# **SCOPING OPINION:**

## **Proposed North Lincolnshire Green Energy Park**

**Case Reference: EN010116**

**December 2020**

Figure 3.2: Indicative Project Site Boundary

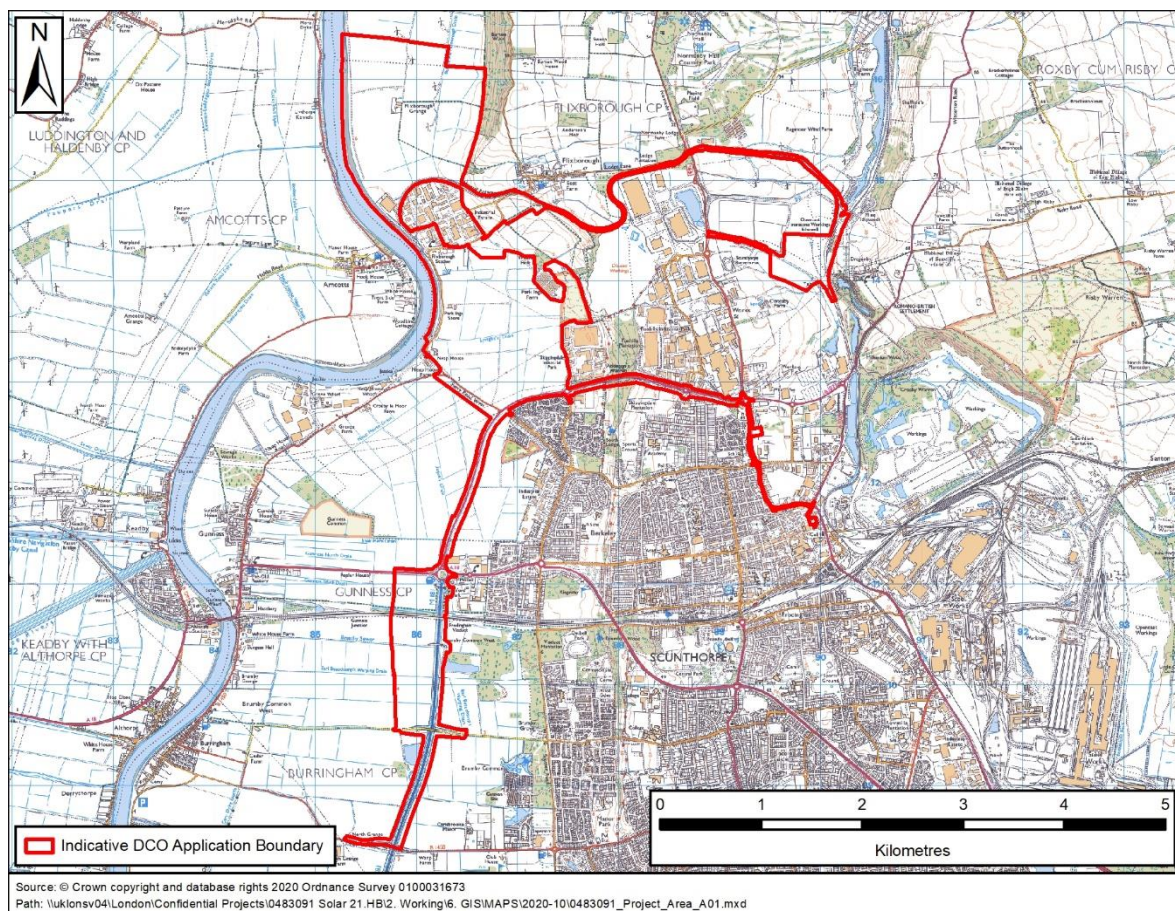
- receptor-specific study areas, as previously set out and defined in the Scoping Report.
- 2.3.5 No plans have been provided within the Scoping Report that depict the layout of the Proposed Development. The ES should provide a plan(s) that depicts the layout of the Proposed Development, as well as the locations of the associated developments.

Figure 11.1: Statutory Sites within 15km and Non-Statutory Sites within 2km of the Project Site

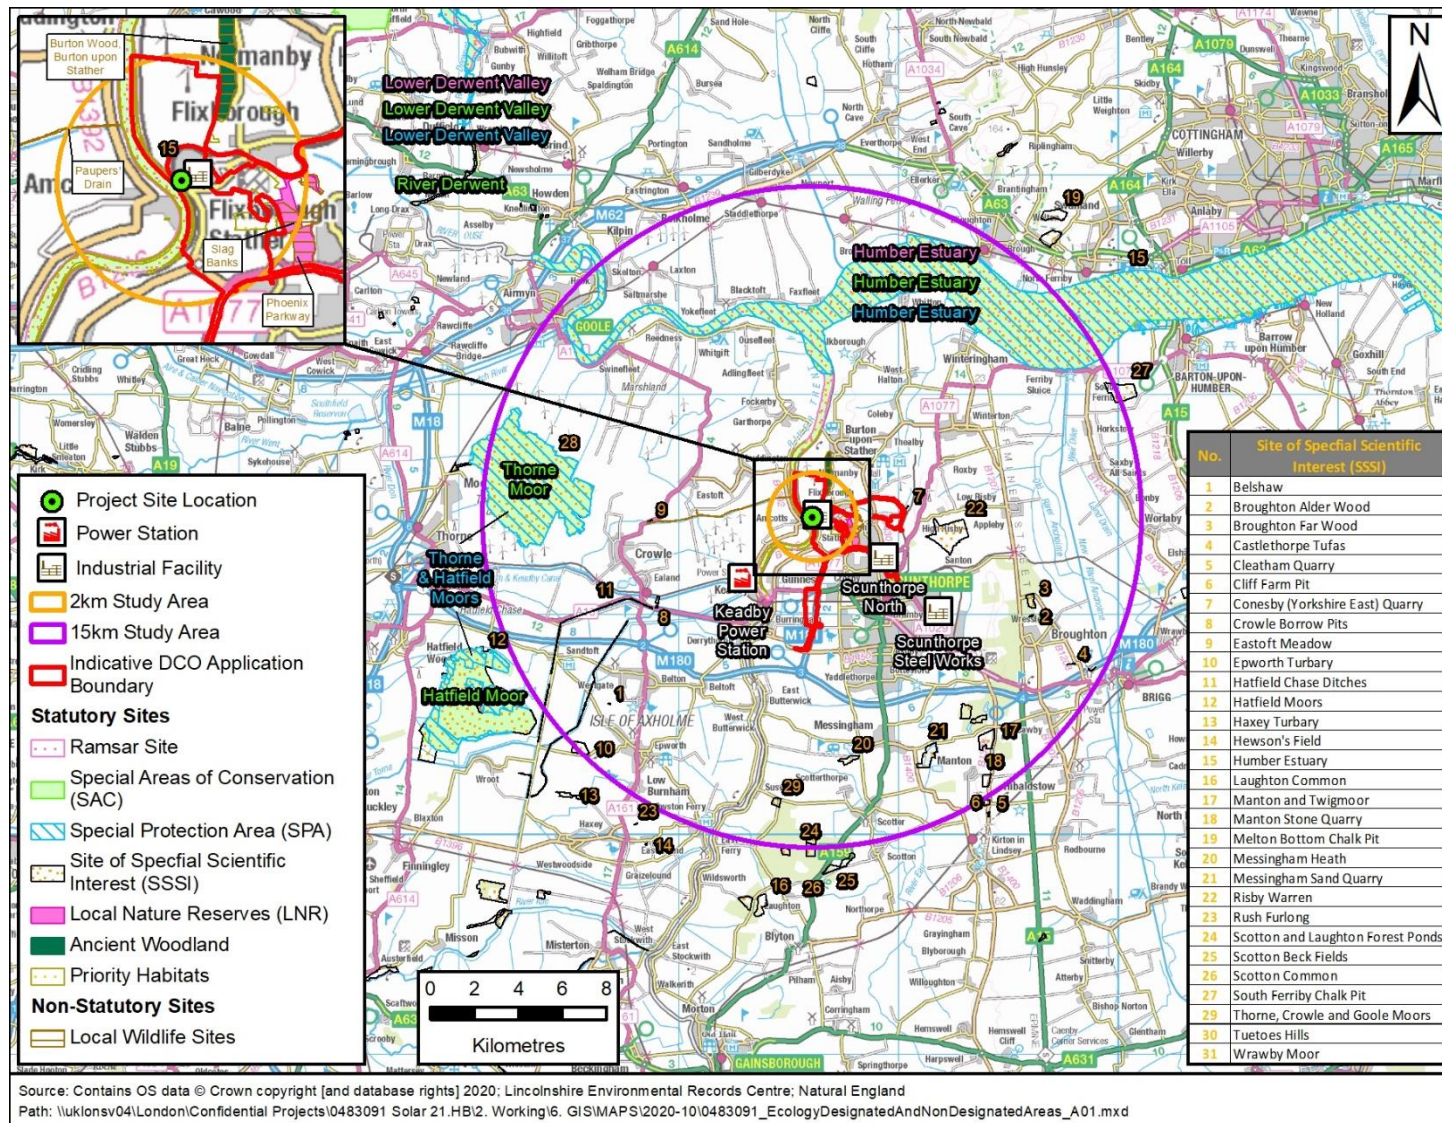
- 2.2.10 The Proposed is located adjacent to the River Trent which is internationally designated as a Special Area of Conservation (SAC) and a Ramsar site, and nationally designated as a Site of Special Scientific Interest (SSSI). Scoping Report Tables 11-1, 11-2 and Figure 11.1 depicts the statutory and non-designated sites within 15km of the Proposed Development.
- 2.2.11 The Proposed Development is in proximity to three Grade I, two Grade II\* and six Grade II Listed buildings, and one Schedule Monument as shown on Figure 13.1. Further Listed buildings and Scheduled Monuments are situated further from the main development site, and these are also presented on Figure 13.1.
